**From:** [REDACTED]  
**Sent:** 10 July 2024 17:52  
**To:** Planning  
**Subject:** 3/2024/0039 Land to the rear of Maycroft Cottage and Chipping House Cottage Hesketh Lane PR3 TH  
**Attachments:** 3 2024 0039 Overlay.pdf

**Reference** 3/2024/0039  
**Location** Land to the rear of Maycroft Cottage and Chipping House Cottage Hesketh Lane PR32TH  
**Proposal** Proposed drilling of six boreholes for ground source heating purposes and associated underground pipework

Lancashire County Council Public Rights of Way neither supports or objects to the application and provides the following.

DOCUMENT TITLE: Site Plan
 Chipping House and Maycroft House
 SCALE 1:500
 @A3
 22_011-CCE-SP_04/05

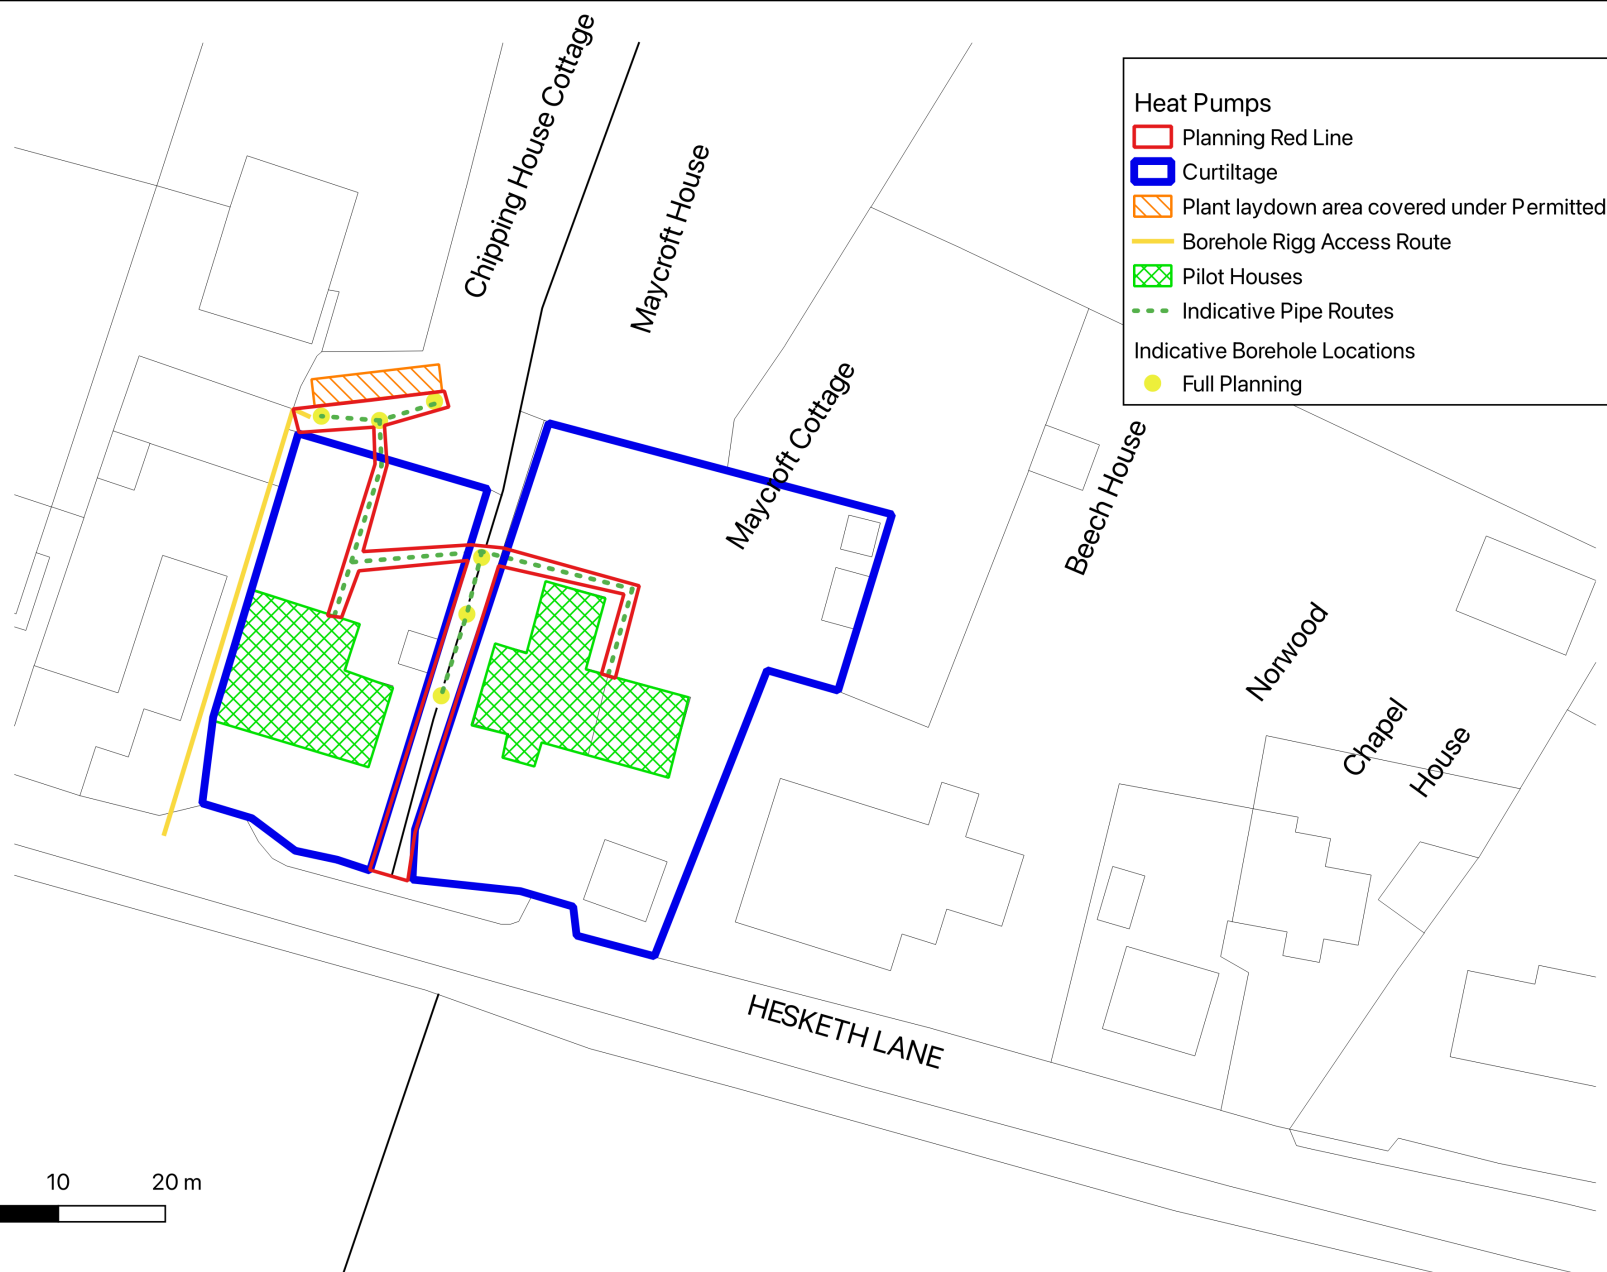
The definitive line of footpath FP0312025 passes through Maycroft House and curtilage of Maycroft Cottage, as shown on the attached plan, not along the permitted walked route between Chipping House Cottage and Maycroft House. Any obstruction of a public rights of way is a criminal offence and something that would impact the sale and potential value of the properties.

The creation of the boreholes and their subsequent existence should not impact users of the permitted walked route. That being so, measures such as a banksman and/or fencing around the boreholes to alert users of the potential dangers from the works and associated machinery should be addressed within the risk assessment to ensure the safety of pedestrians until the permitted path is reinstated to an equal, if not improved, surface condition of that prior to the works.

Any changes in ground level or installation of drainage should ensure that surface water is not channelled towards or onto a public right of way – this is to ensure public rights of way are not exposed to potential flooding or future maintenance issues.
